From: Aldingbourne Parish 
Sent: 03 April 2017 12:08
To: Lucy Harding
Cc: Martin Beaton; Cathy + Dan Turner
Subject: AL/107/16 RES Land west of Westergate St and east of Hook Lane

Our Ref: W1950/RCA/4434

31 March 2017

Re: Planning Application AL/107/16/RES : Land West of Westergate Street and East of Hook Lane, Westergate, PO20 3TE
Comments in relation to Flood Risk Matters

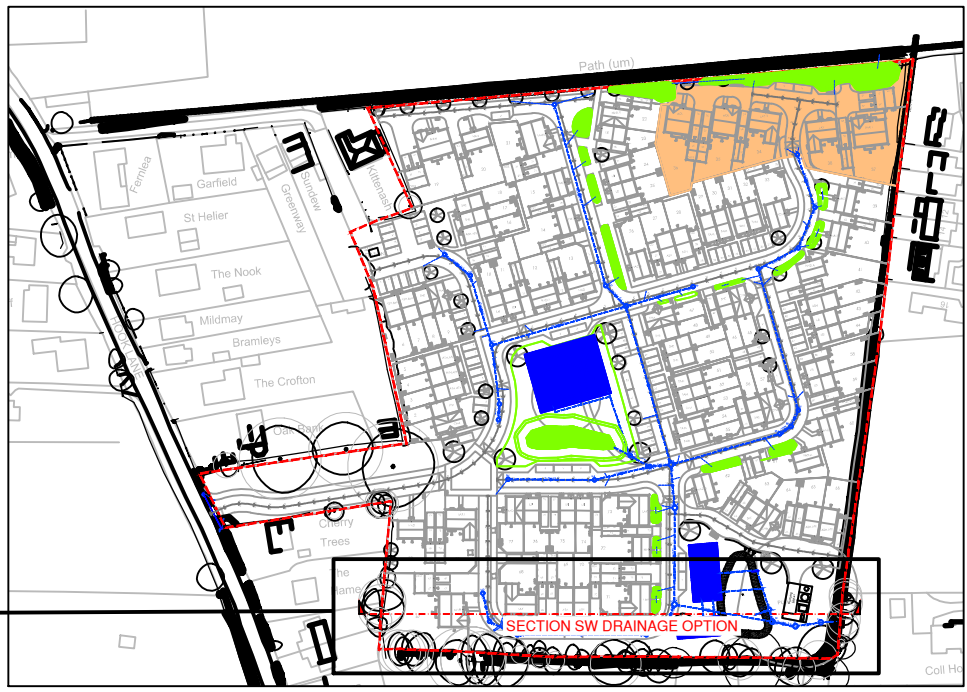
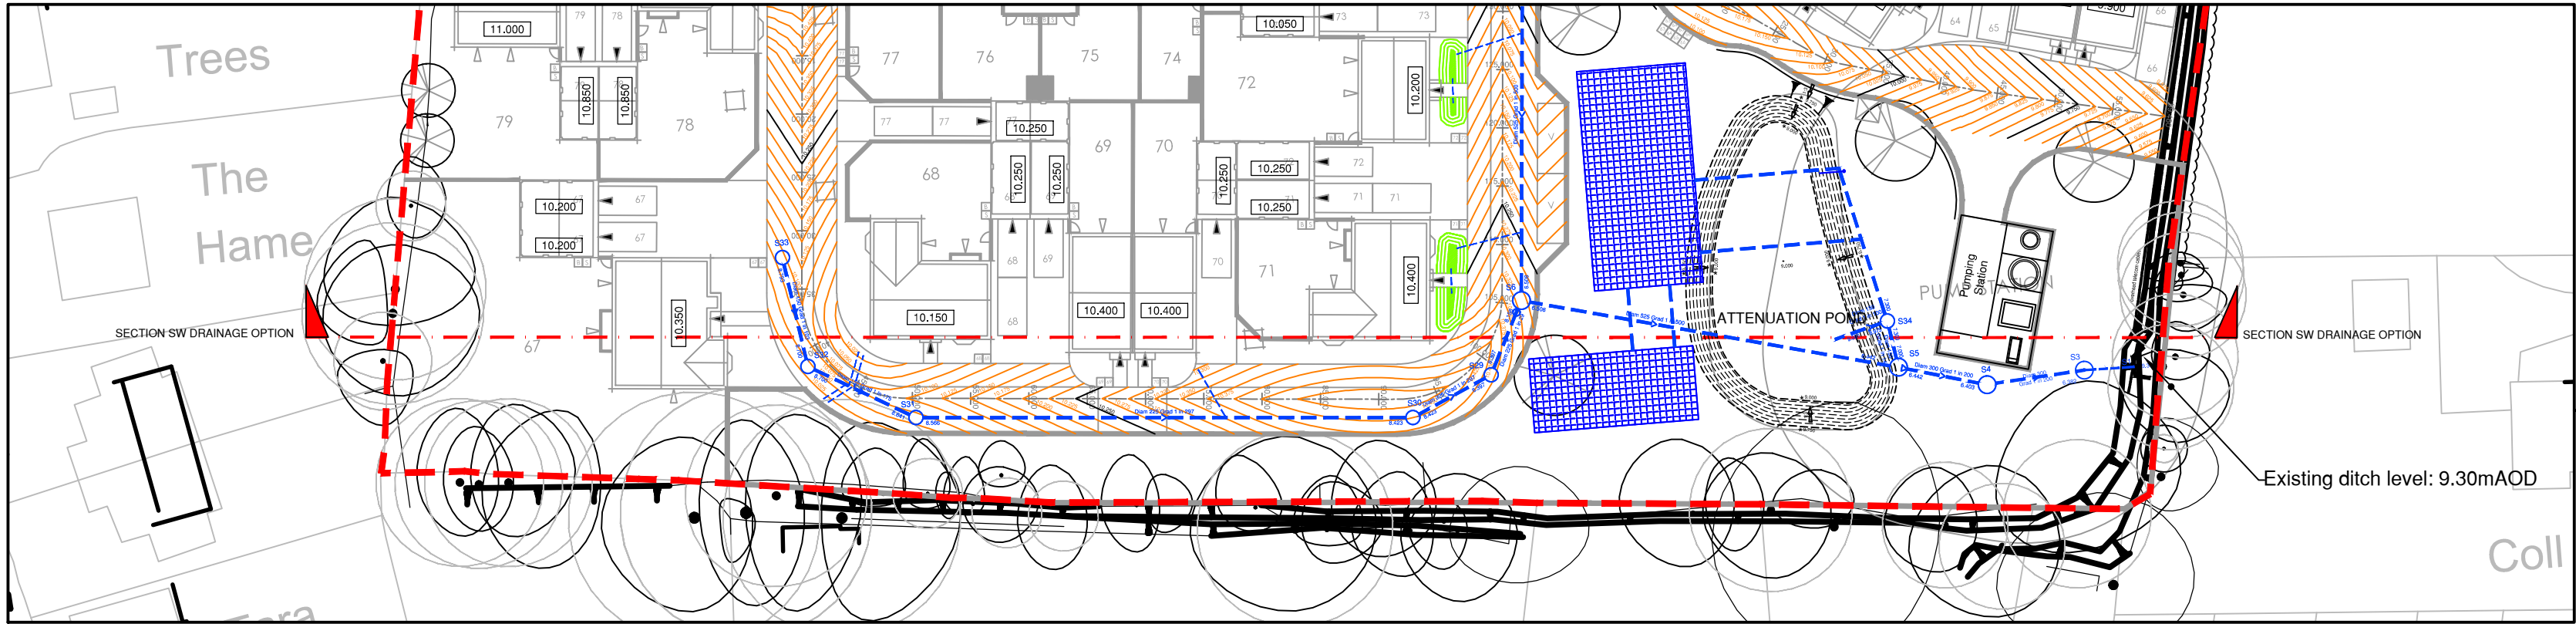
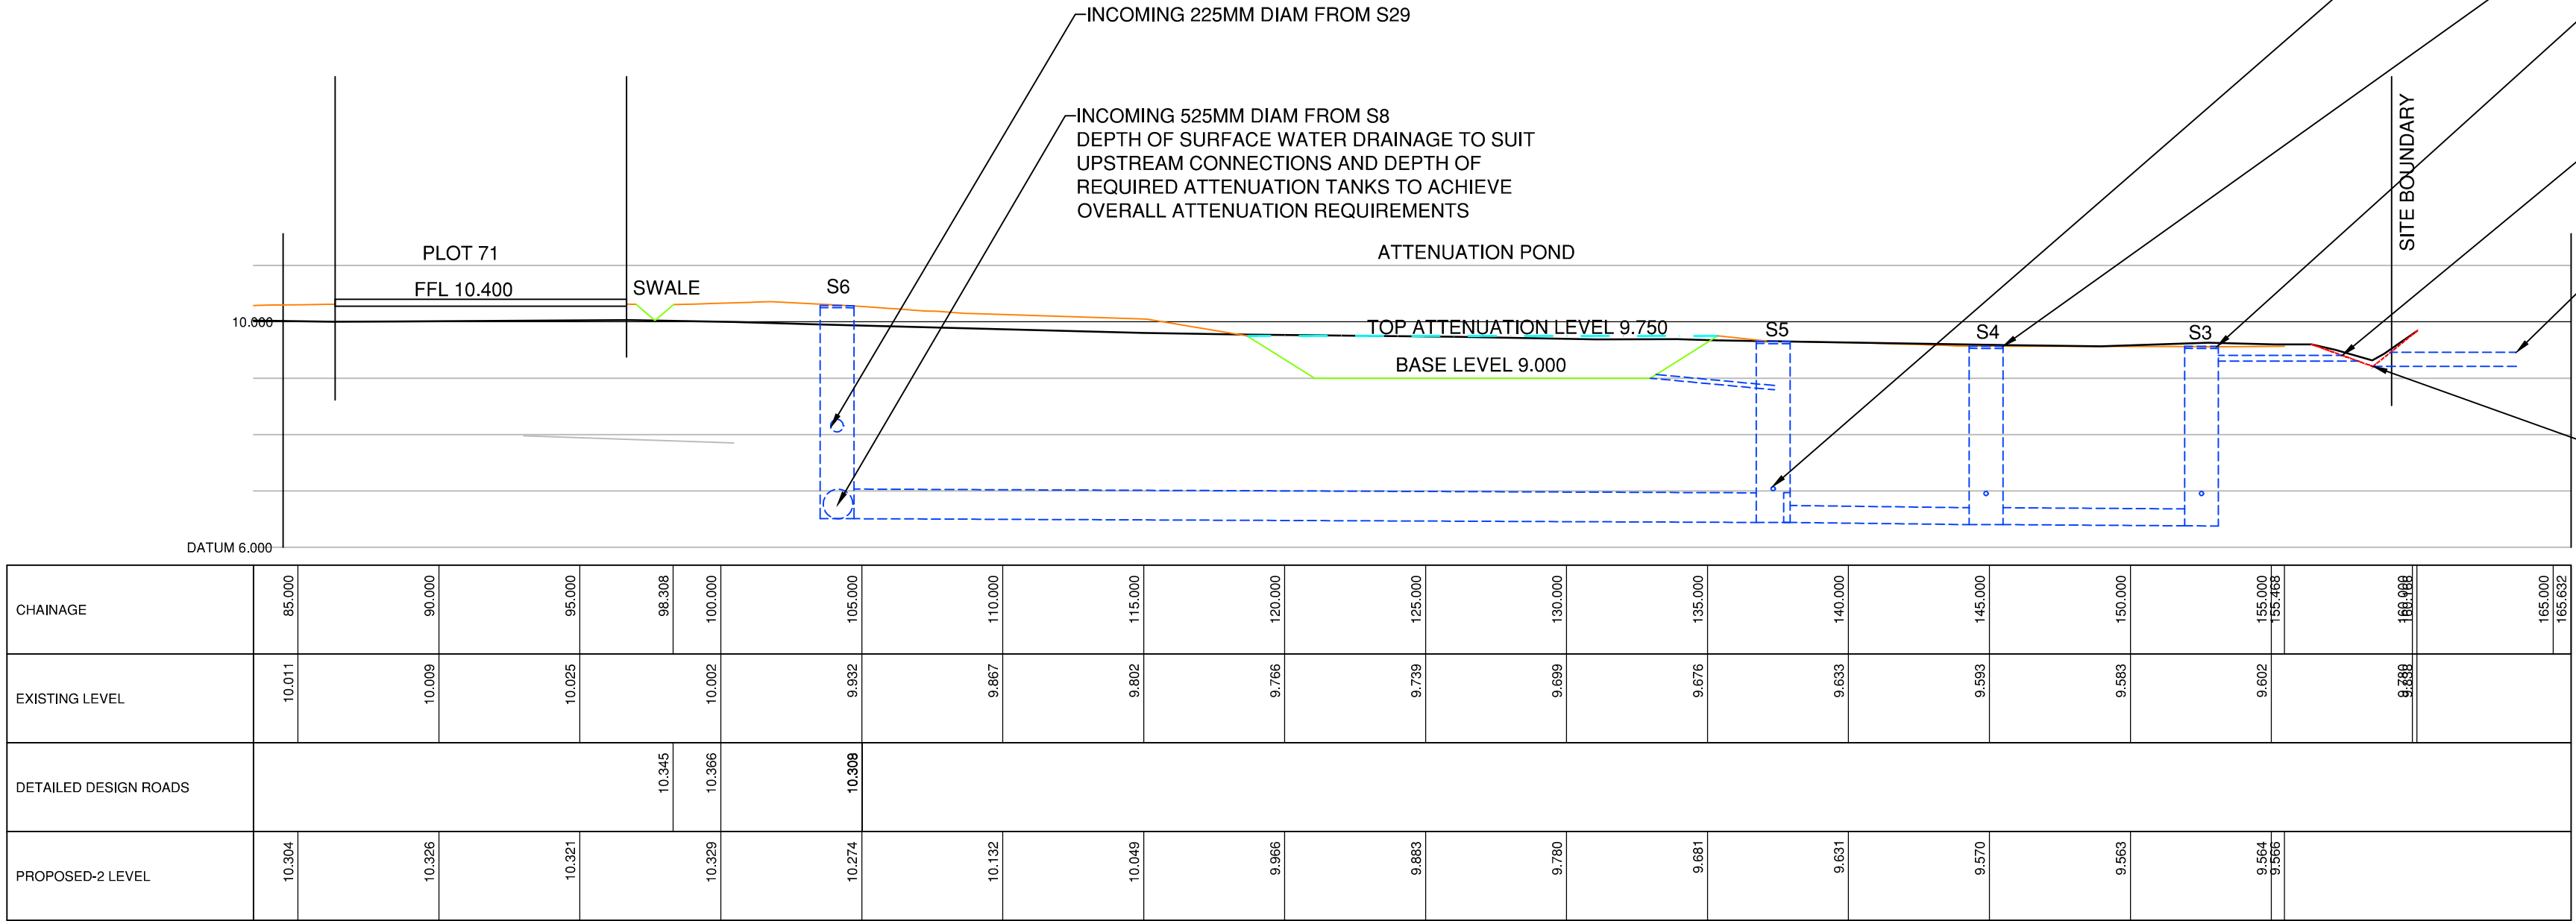
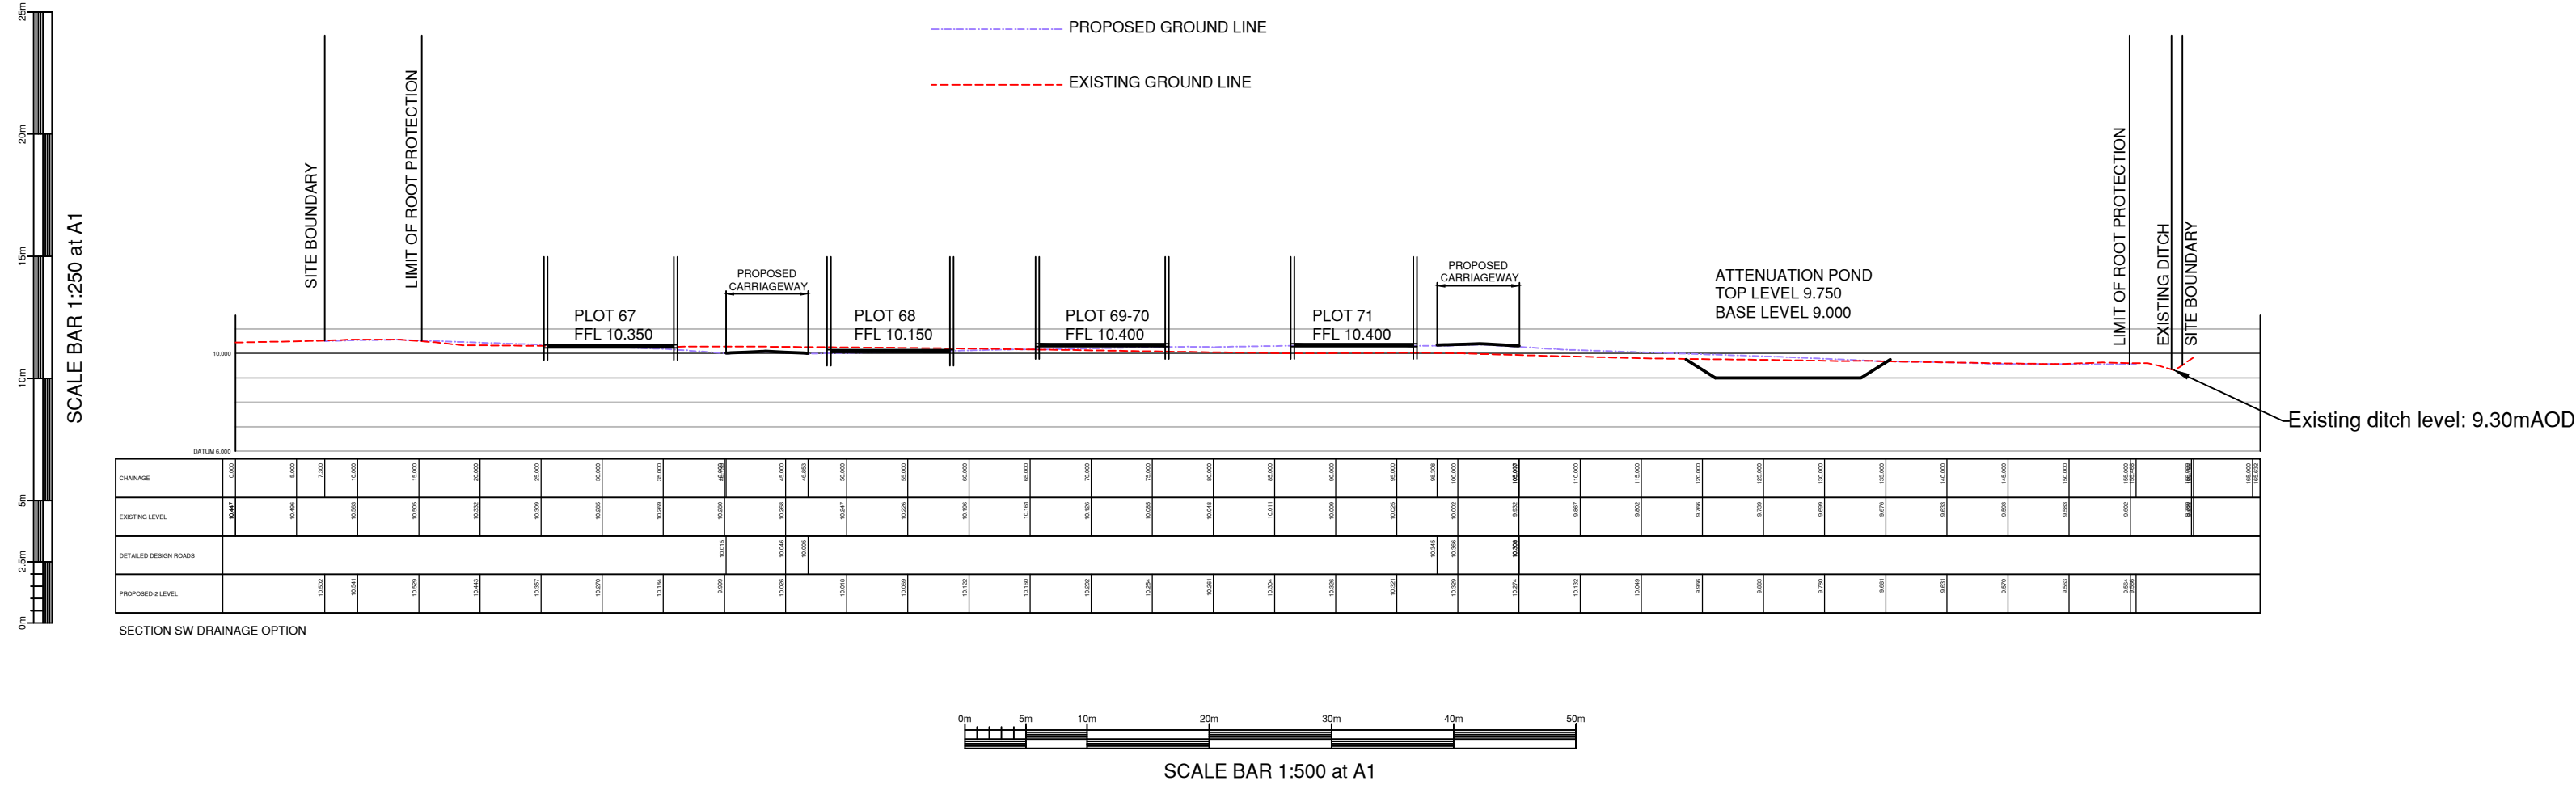
Surface Water:- The surface water drainage strategy drawing shows a complex layout of surface water drains. A cause for concern are the large areas of road or hardstanding which do not appear to have any drainage provision. The access road for example has no drainage provision.

The drainage strategy has a relatively small area draining to a ditch in the north-east corner of the site but it is unclear how the discharge will be controlled as the outlet shown from the balancing pond (Swale 3) is inaccessible. It will be necessary to have a control structure here which can be easily accessed. It is unclear whether Swale 2 is intended to be part of the drainage arrangement for this north-east corner as no drainage pipes are shown.

The existing site (apart from the north east corner) drains in two directions; to a 225mm diameter pipe midway along the eastern boundary and to a drain (possibly buried) in the south-east corner of the site. The drainage strategy does not replicate this arrangement and instead appears to comprise draining the whole site to the 225mm diameter drain on the eastern boundary even though the exceedance flow path shows the site falling to the south-east corner. It is of considerable concern that the strategy proposals rely on a one metre wide easement

alongside the eastern boundary ditch which only has an access at one end and that is over an area of private car parking; there is a high probability that adequate maintenance of this ditch will not be feasible.

The substitute drainage strategy now has a number of what are termed “roadside swales” with many of them located in what would normally be considered as the front gardens of properties. There is a pipe shown from these swales to connect to the main surface water drains but it is not clear how these swales are intended to be filled and control flows. The table on the drainage strategy drawing shows that these roadside swales will only be “*effective storage during exceedance events only*” and if they are used so infrequently the residents are unlikely to understand why they are there and there will be pressure for them to be filled in and grassed. It is therefore likely that at the time they are needed they will no longer exist.

The drainage strategy shows that there will be a pumping station on the surface water drainage system with a link back to the balancing pond; this is presumably to divert flows which are in excess of the pump rate back into the balancing pond for storage. For this to function it would be necessary to either have the surface water sewer system surcharged for prolonged periods (or maybe always) or the balancing pond would need to be very deep. The surface water pumping station shown on the plan is very small, has no vehicular access and is highly unlikely to meet adoptable standards. Southern Water will not adopt the surface water pumping station in its current format (and almost certainly would also not adopt the surface water sewer system either). If the surface water sewers are surcharged for prolonged periods (or always) their effectiveness would be seriously prejudiced and would result in serious long term maintenance problems and in the event of a significant storm occurring would result in flooding within the site.

There is very little fall across the site and it is therefore inevitable that the proposed underground storage crates will be relatively deep and probably below the groundwater level so measures will be needed to prevent them floating. The surface water drains will progressively deepen (in order to have a gradient on them) and by the time the drainage system gets to the pumping station the sewers are likely to be several metres deep; the cross section drawing shows these drains to be almost 4 metres deep. The balancing pond nearest the pumping station is shown as having a base level at 9.0m AOD and a top water level of 9.75m AOD giving an operating range of 750mm. However, the surface water drains will need to surcharge by over 3 metres before any water gets into the pond; this means that the pond will not actually attenuate any flows and will probably be used infrequently.

The drainage network shows a petrol interceptor upstream of the pumping station but this will be surcharged for prolonged periods and will therefore not function in accordance with the manufacturers specifications.

I recommend that you request a planning condition that the surface water drainage system and pumping station are built to adoptable standards (even though it is unlikely that they are adopted by Southern Water) and that an adequate long term maintenance regime is approved and implemented.
